From: Laura Gibbons
Sent: 18 June 2018 11:18
To: Planning.Responses
Subject: RE: Planning Consultation on A/82/18/DOC

Engineers Comments Relating to Conditions 6 and 7

APPLICATION NO: A/82/18/DOC

Site Address: Quiet Waters Roundstone Lane Angmering BN16 4AX

Drawing Title:
Proposed Site Layout

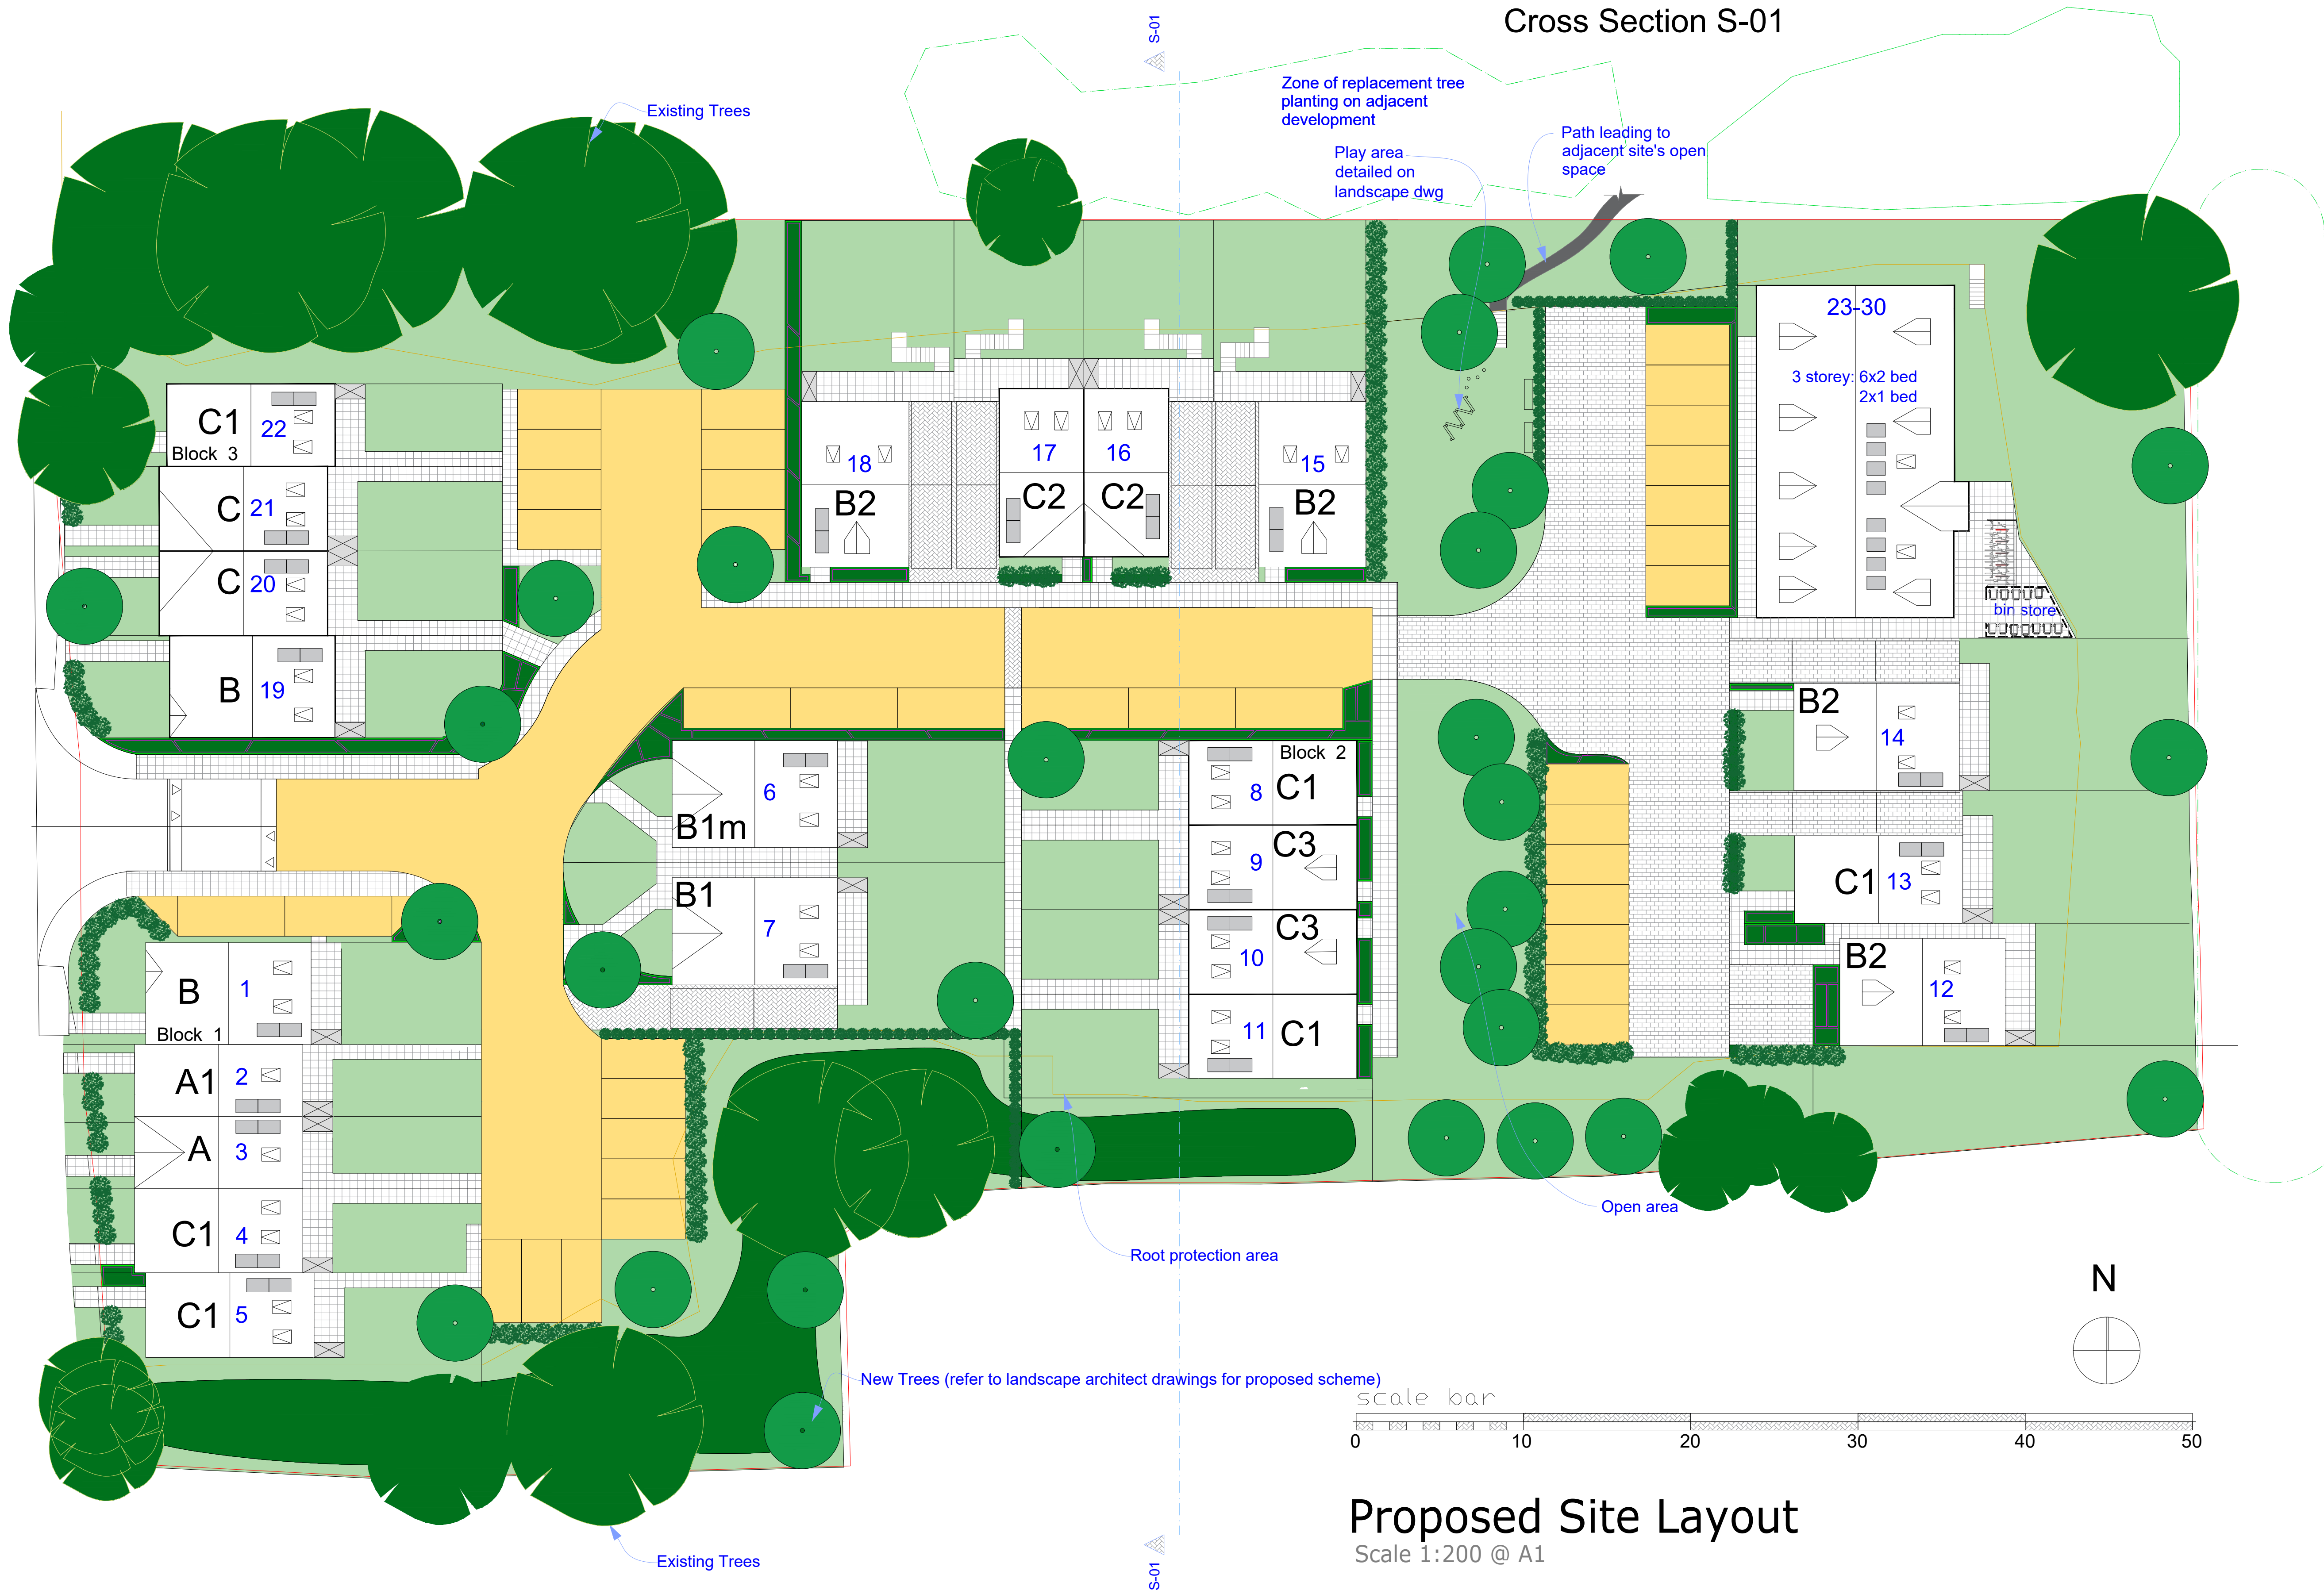
- Insufficient detail regarding calculations has been provided. Please provide Microdrainage printouts.
- The drainage layout plan provided shows a different proposed arrangement of the site to other plans submitted. Please confirm which layout is correct.

Drawing Title:
Proposed Materials Layout

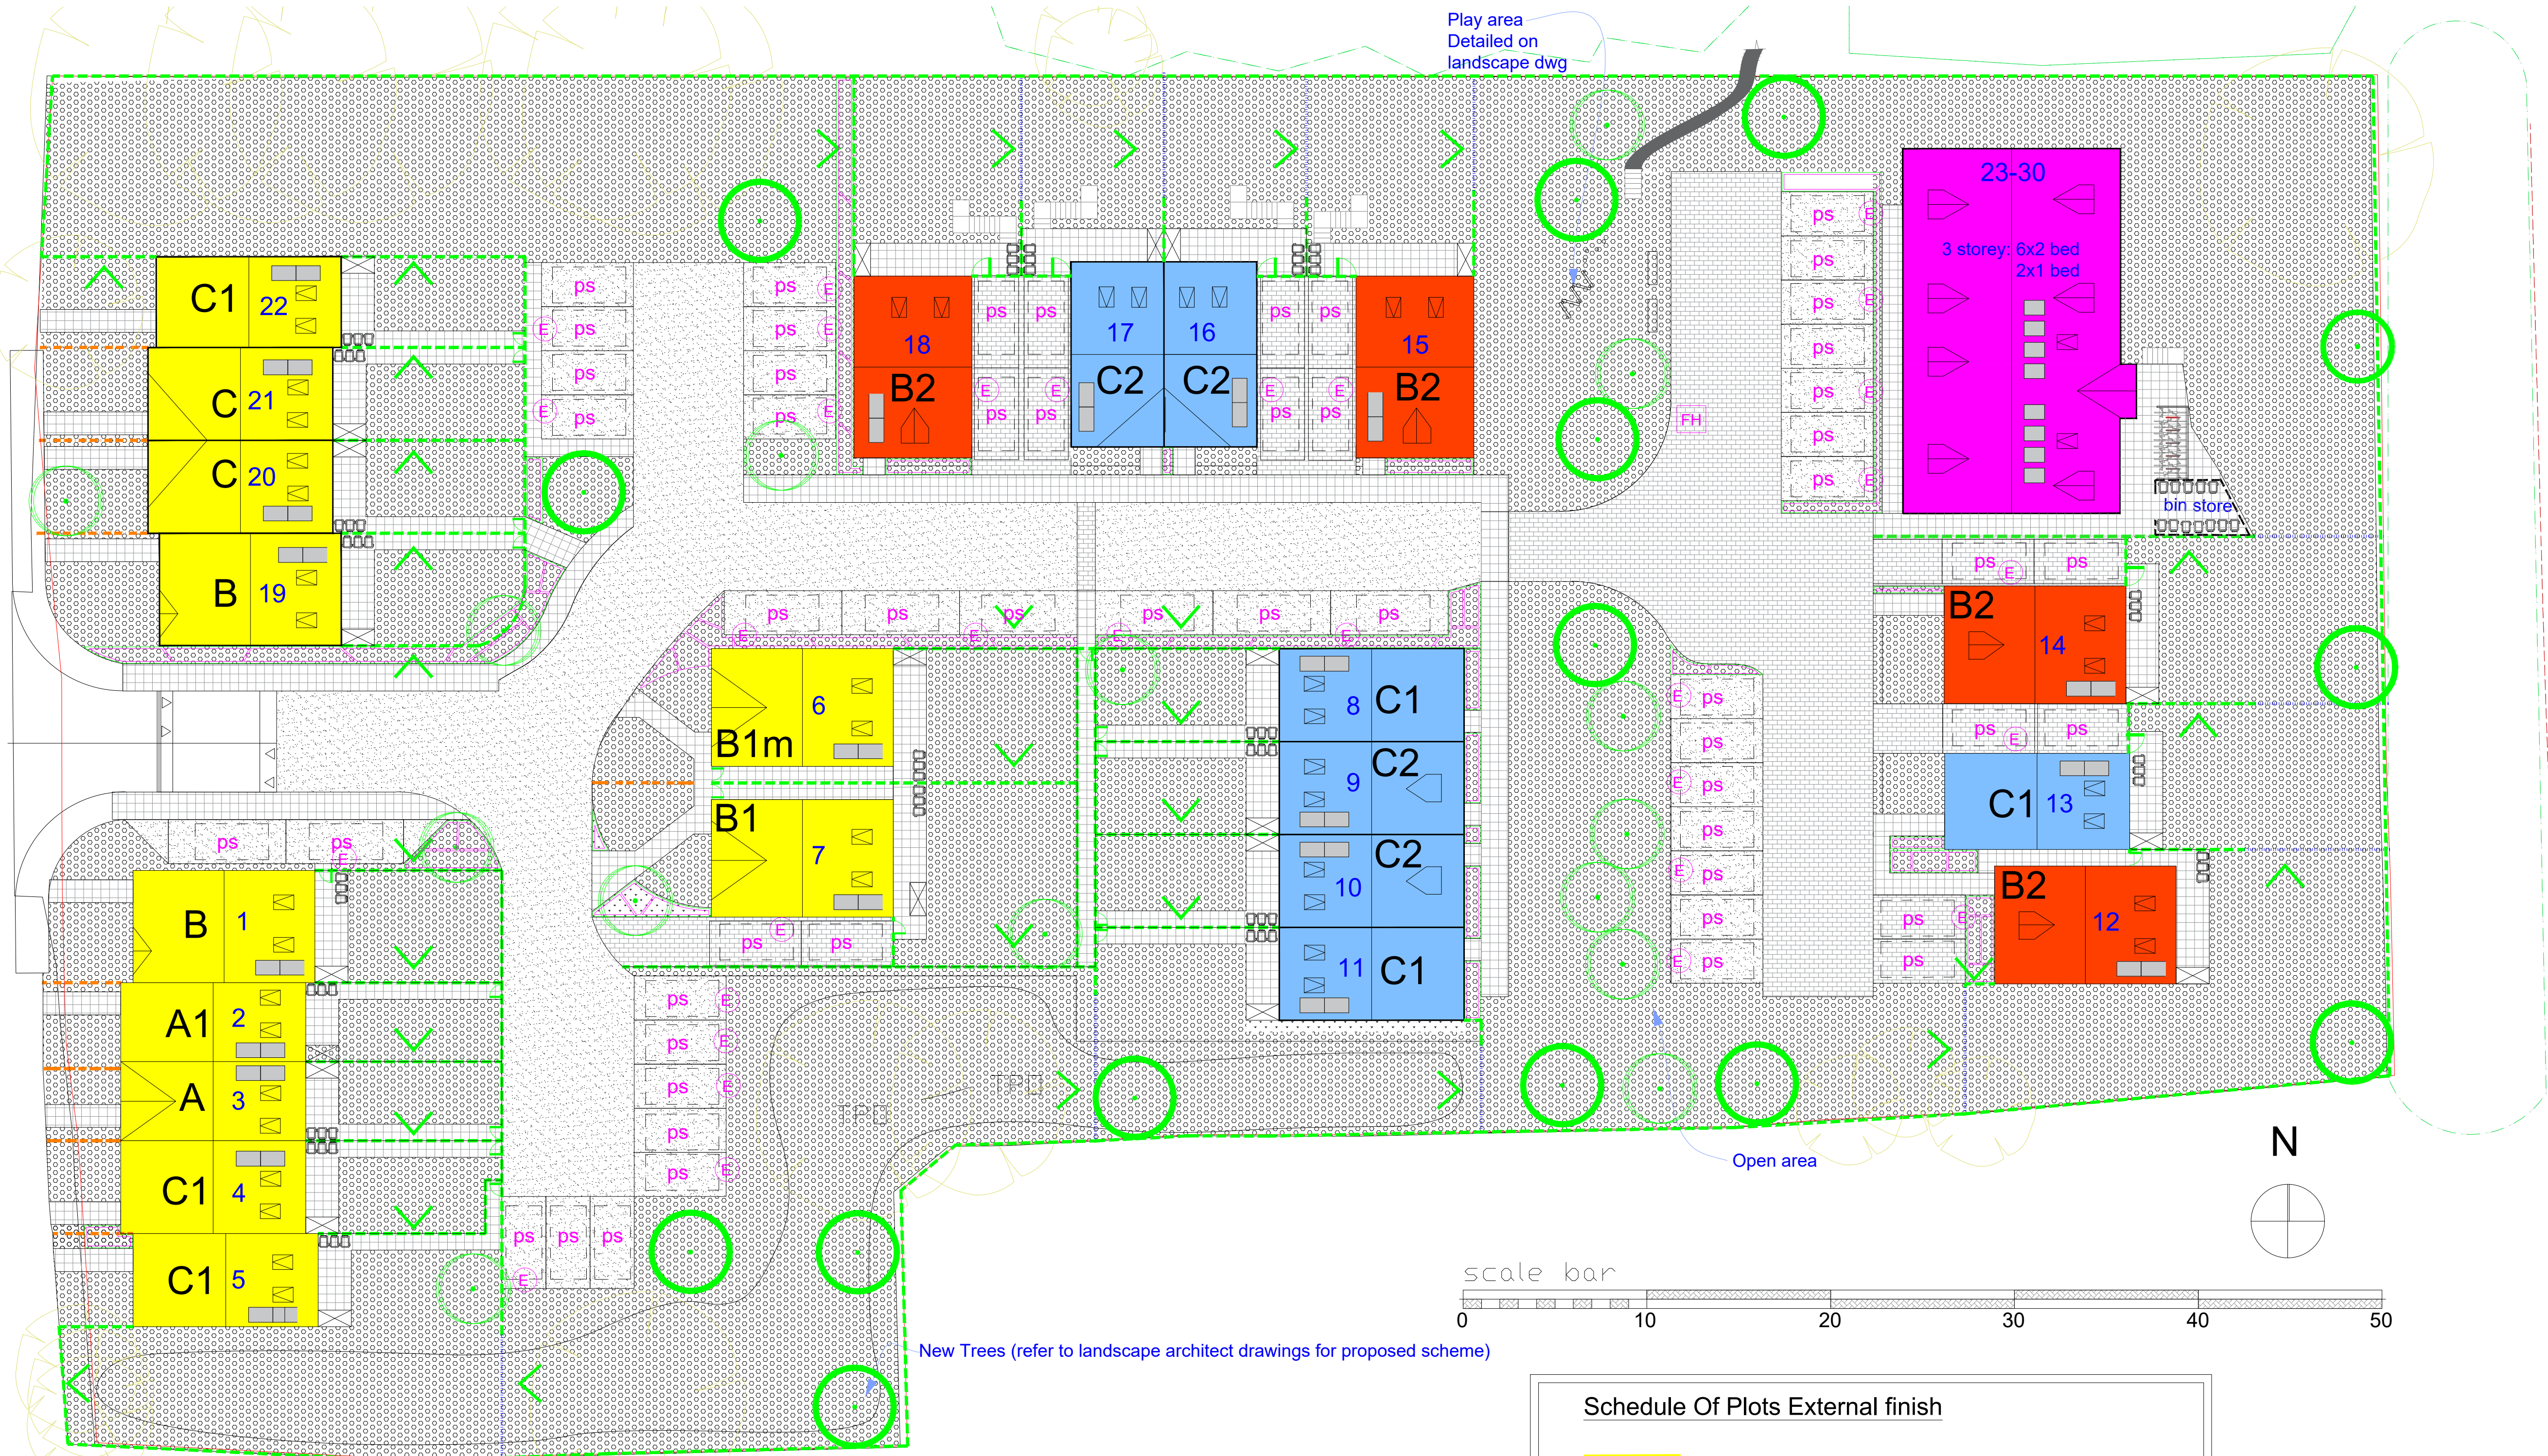
- Full details of the proposed boreholes will need to be provided before the condition is discharged.
- We would encourage that the proposed porous pavement is left un-tanked to allow for some infiltration.
